TRANSMITTAL SHEET

<p>To: City of Mercer Island</p> <hr/> <p>Company: Department Services – Building & Planning</p> <hr/> <p>Address: 9611 SE 36 Street Mercer Island, WA 98040</p> <hr/>	<p>From: Erik Voris</p> <hr/> <p>Project: Project 2312-031</p> <hr/> <p>Date: 2/12/2024</p> <hr/> <p>Regarding: Correction Cycle#1</p> <hr/>
--	--

Planning Review Corrections received on 1/31/24 from Molly McGuire

1 PARTIAL NORTH ELEVATION
A4.1 SCALE: 1/4" = 1'-0"

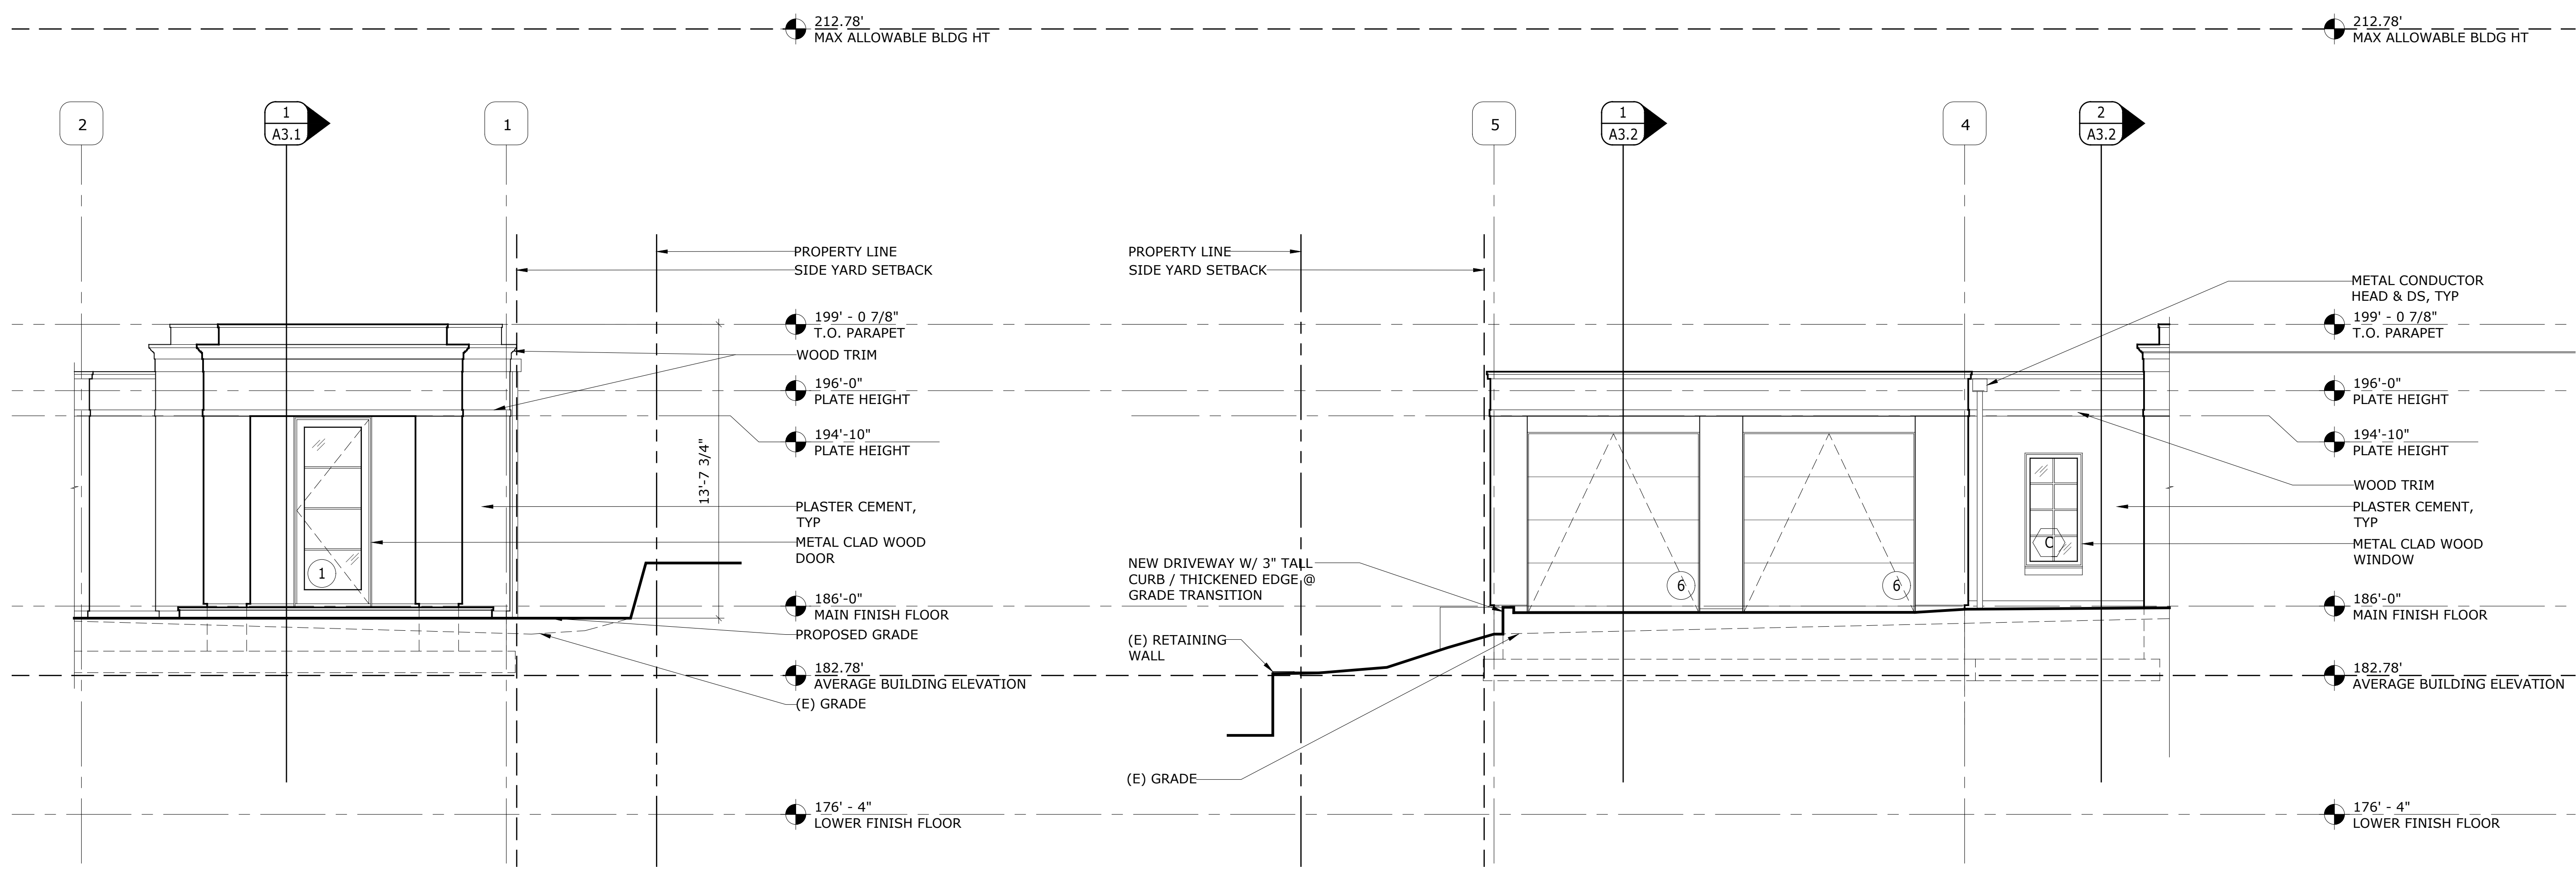
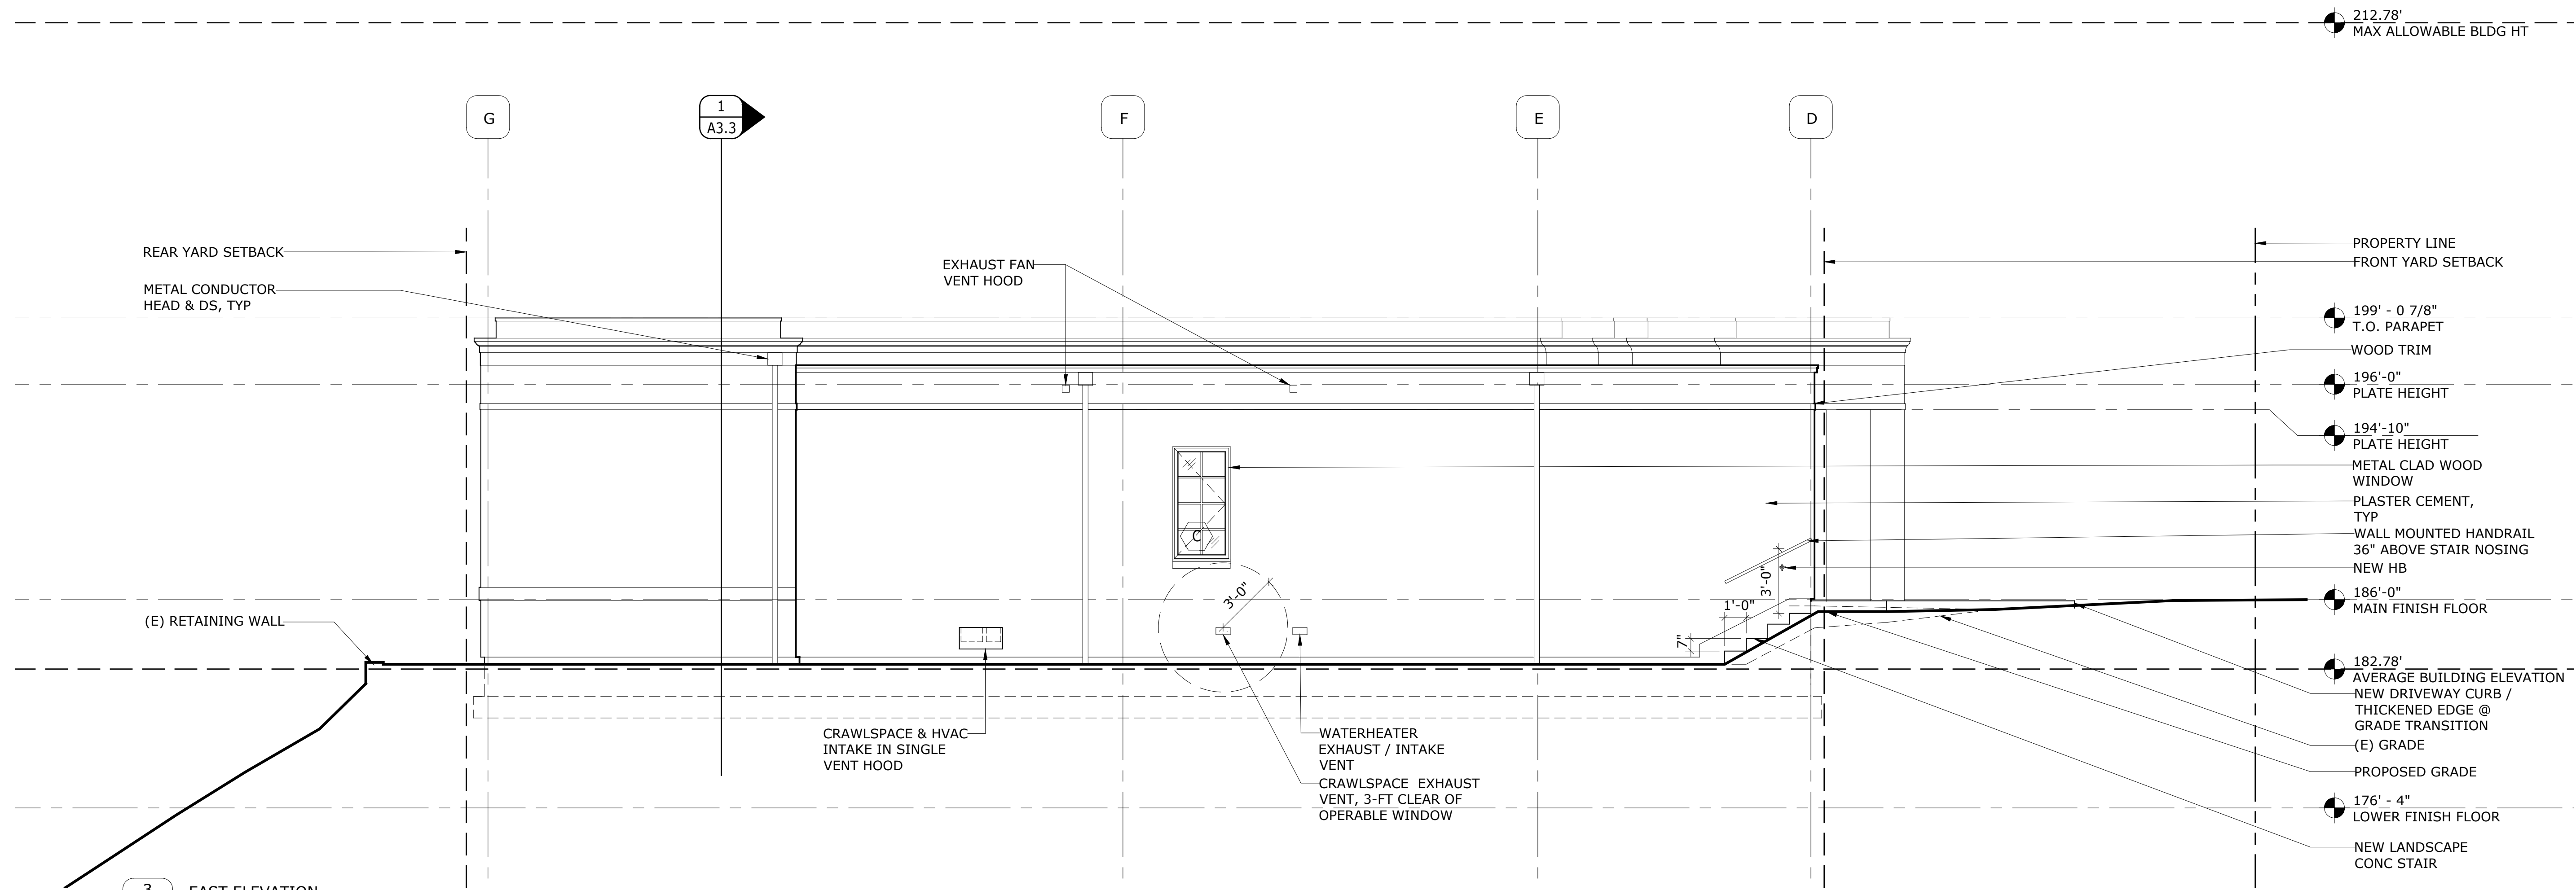
9. Sheet A4.1- "Average Grade" should be corrected to "Average Building Elevation" or "ABE".
10. Sheet A4.2- Dimension downhill facade height per MICC 19.02.020(E)(2): Maximum building height on downhill building facade. The maximum building facade height on the downhill side of a sloping lot shall not exceed 30 feet in height. The building facade height shall be measured from the existing grade or finished grade, whichever is lower, at the furthest downhill extent of the proposed building, to the top of the exterior wall facade supporting the roof framing, rafters, trusses, etc.

- 8 - A clarifying note was added to the hardscape path and stair along the west side of the structure on sheet A1.1.**
- 9 - The Average Grade notes on the building elevations has been revised to Average Building Elevation.**
